**Re: Opus Transport Apartments -FINAL  
Traffic Impact Study (M15D023H)**  
Engineer's Stamp 8-2-24  
Via email jroberts@tierrawestllc.com

The subject Traffic Impact Study (Study) received on August 15, 2024, has been reviewed and is approved by the City of Albuquerque Planning Development Transportation Section.

**Re: Opus Transport Apartments  
Traffic Impact Study (M15D023H)**  
Engineer's Stamp 7-10-24  
Via email jroberts@tierrawestllc.com

Re: [2023065] – OPUS Transport Apartments – Flightway Ave. at University Blvd. in Albuquerque, NM.

Figure 4: Proposed Striping and Intersection Mitigation

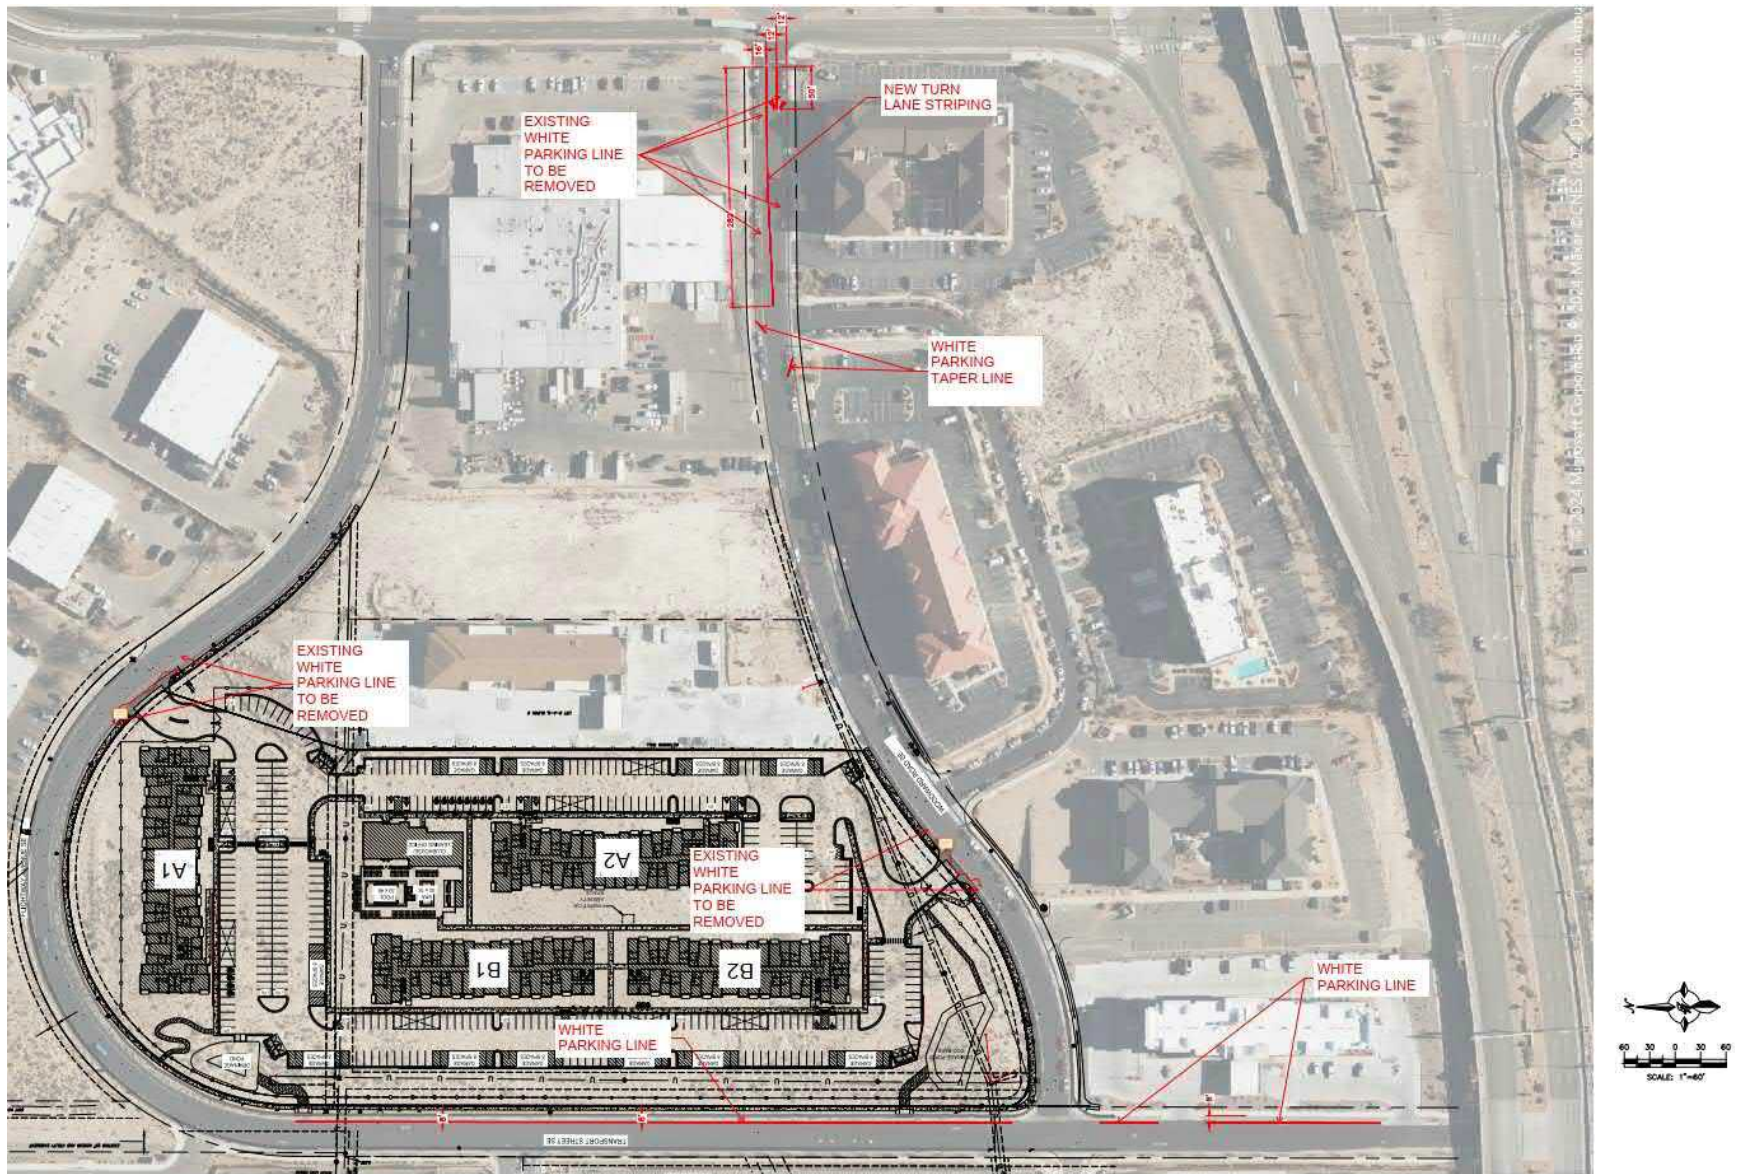
Required infrastructure improvements per the Study include pavement markings as shown on Figure 4, p. XV.

1. Please include the striping exhibit V2.
2. Revise the analysis at Woodward Rd and University Blvd using eastbound right and left turn lanes.

- 1) Please include the striping exhibit V2.

1. The main thing I was getting at with my previous comment to "Please extrapolate/provide details on the ...striping...." was to get an exhibit so it is easy to see the limits on Flightway/Transport centerline, also to get the street width on Transport to check the driving width with the on-street parking and I was hinting at turn lane pavement markings at eastbound Woodward Rd at University Blvd.

3. Include eastbound Woodward Rd right and left turn lanes at University. This means removing on-street parking between University Blvd and the first driveways west of University. I checked the Site Plans/TCLs for the sites on the north and south side of Woodward Rd and neither of them had required on-street parking to meet their parking requirements. Please propose how far west to stripe from University. Please include in exhibit above.

*Response: Tierra West LLC. has attached the revised striping exhibit V2 to this letter as well as included it within the body and appendix of the report to reflect the recommended improvements in striping for on street parking and the installment of an additional eastbound left-turn lane on Woodward Rd. at University Blvd.*

Figure 17: Proposed Striping and Intersection Mitigation

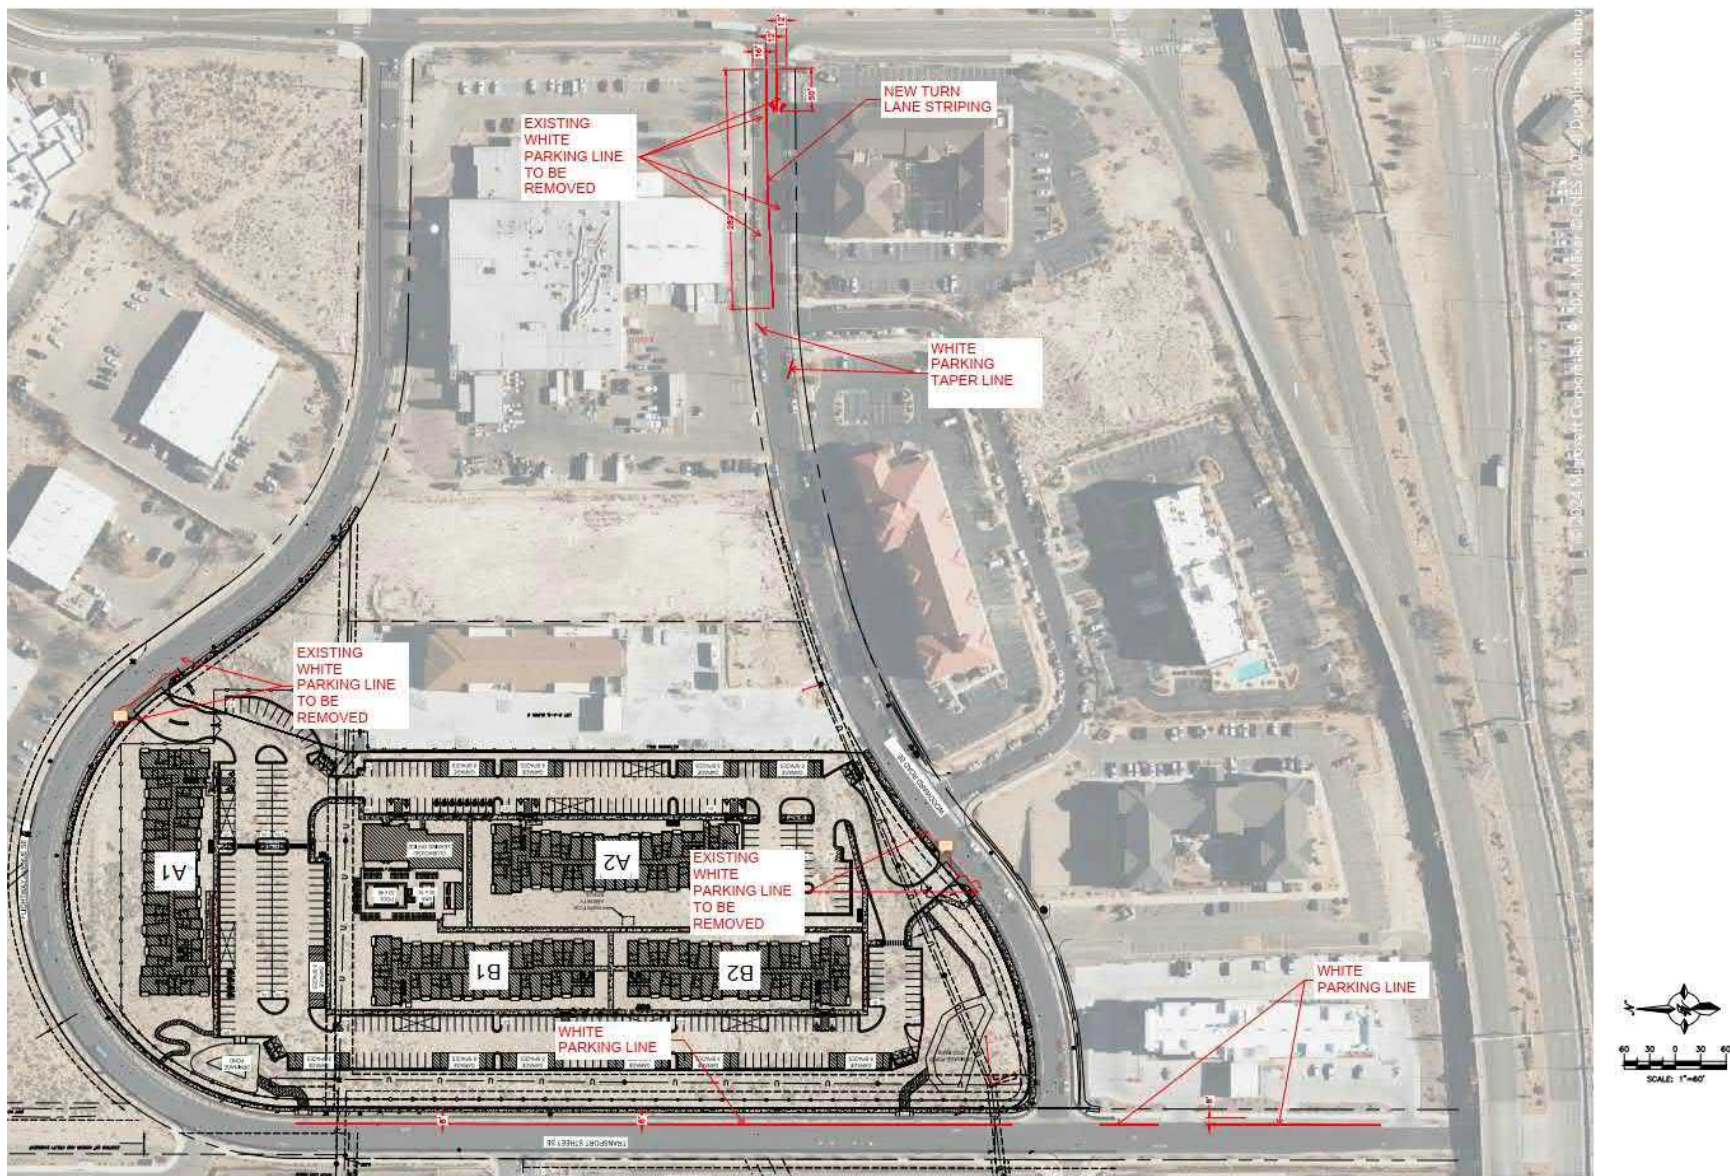
- 2) Revise the analysis at Woodward Rd. and University Blvd. using eastbound right and left-turn lanes.

I checked with our Traffic Ops folks and did some research on centerline striping and we do not want the centerline striping as having no centerline is a traffic calming measure. Of course, we will need it to delineate the lanes at the Woodward eastbound approach at University and we like the on-street parking.

Your last exhibit ran off the page at the south end of Transport St. Please have the exhibit show all proposed improvements.

*Response: Tierra West LLC. confirms the revised analysis for the intersection of Woodward Rd. at University Blvd. The mitigated improvements of the Woodward Rd. at University Blvd. intersection were successfully evaluated by separating the shared eastbound left-turn and right-turn lane while increasing the storage capacity of the eastbound approach volume. The mitigation measures significantly reduced the V/C ratio, delay in seconds, and the 95<sup>th</sup> percentile queue length compared to the horizon year build volume under existing conditions. These improvements also include the elimination of the on-street parking along the north and south side of Woodward Rd.*

*“The mitigations provided for this intersection include implementing an additional eastbound left lane. The analysis of this report concludes that*

*improving the intersection geometry of Woodward Rd. at University Blvd.  
intersection improves the Level of Service from a LOS "C" to a LOS "A."*
